FORMAL STRATEGIC OBJECTION: STATE SIGNIFICANT DEVELOPMENT

Development Project: 138 Maroubra Road Mixed-Use Proposal (SSD-81426710)

Objecting Party: Surrounding Locality Residents & Adjoining Neighbours

ADDITIONAL SHADOW
CAST BY PROPOSED
DEVELOPMENT

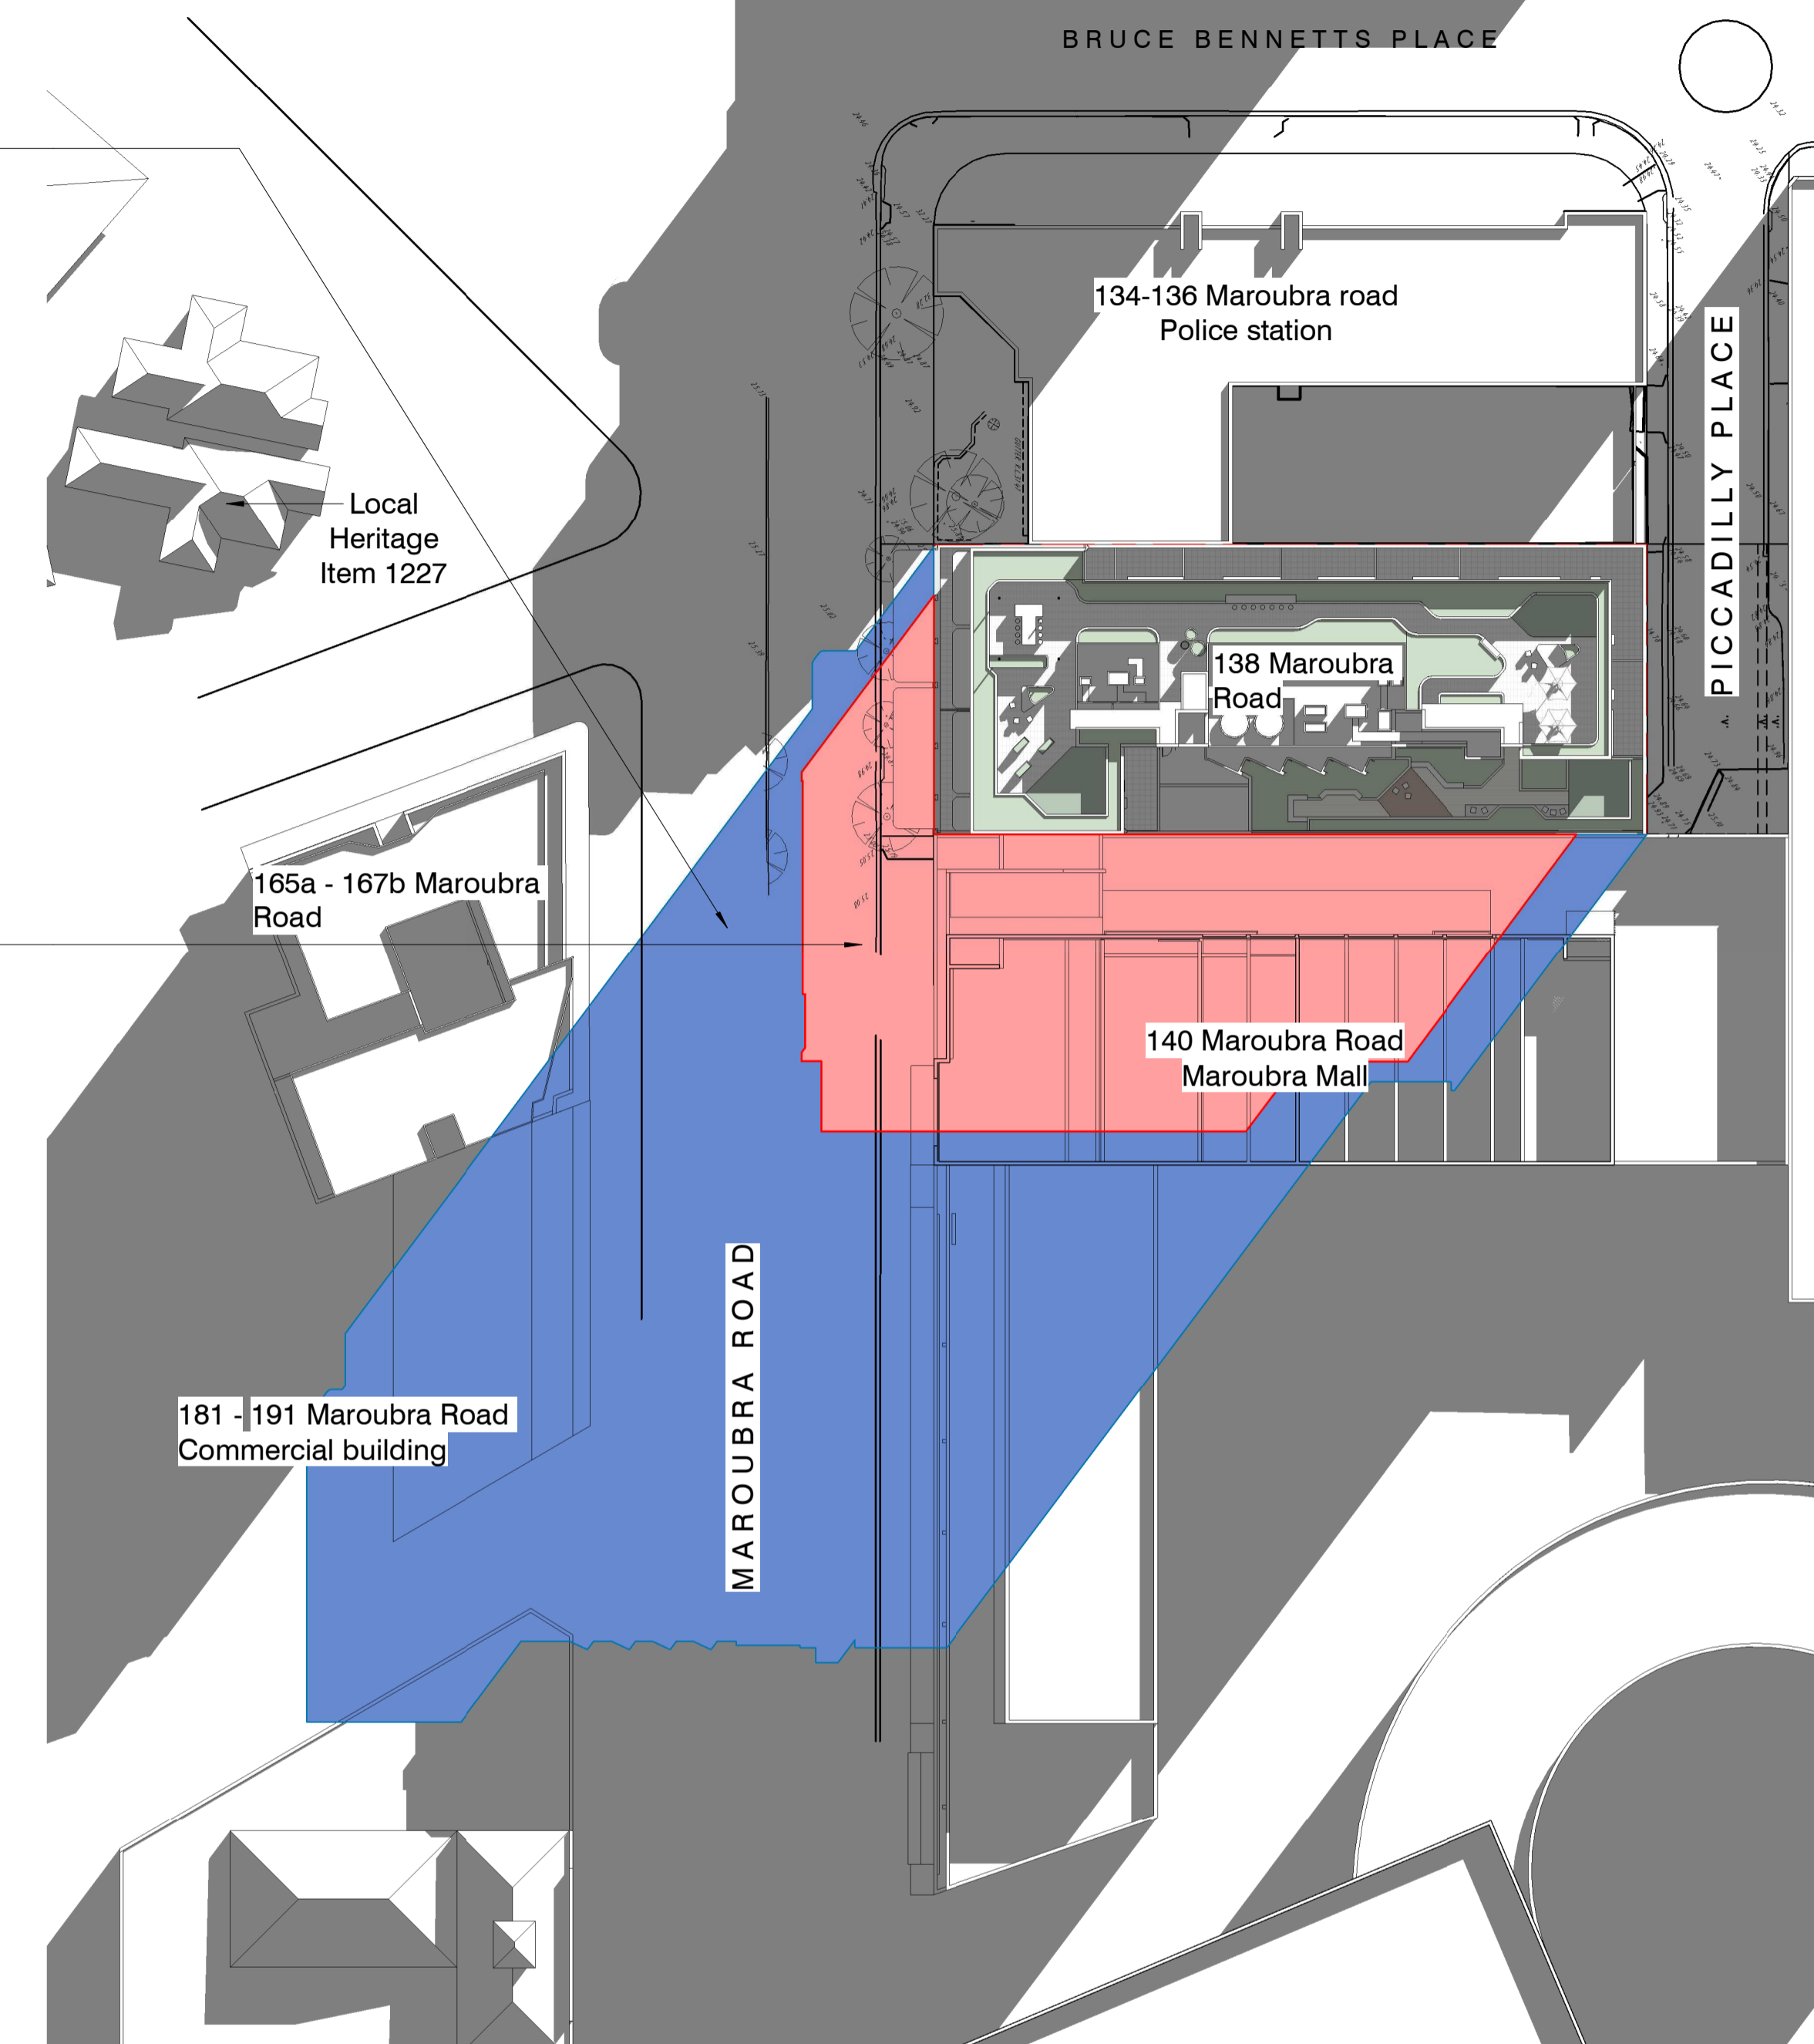
The applicant's submitted shadow modeling relies on broad, regional averages under the Apartment Design Guide (ADG), completely overlooking the localized microclimatic reality of adjoining homes. Building a deep, vertical 10-storey structure directly to the west completely cuts off essential afternoon daylight.

Natural sunlight is a basic requirement for health, physical comfort, and natural apartment temperature control. Stripping adjacent homes of afternoon light hours degrades the baseline well-being of the surrounding community. This loss is felt most acutely by our less-mobile senior residents who stay indoors and rely heavily on natural sunlight for physical health and daily internal warmth.
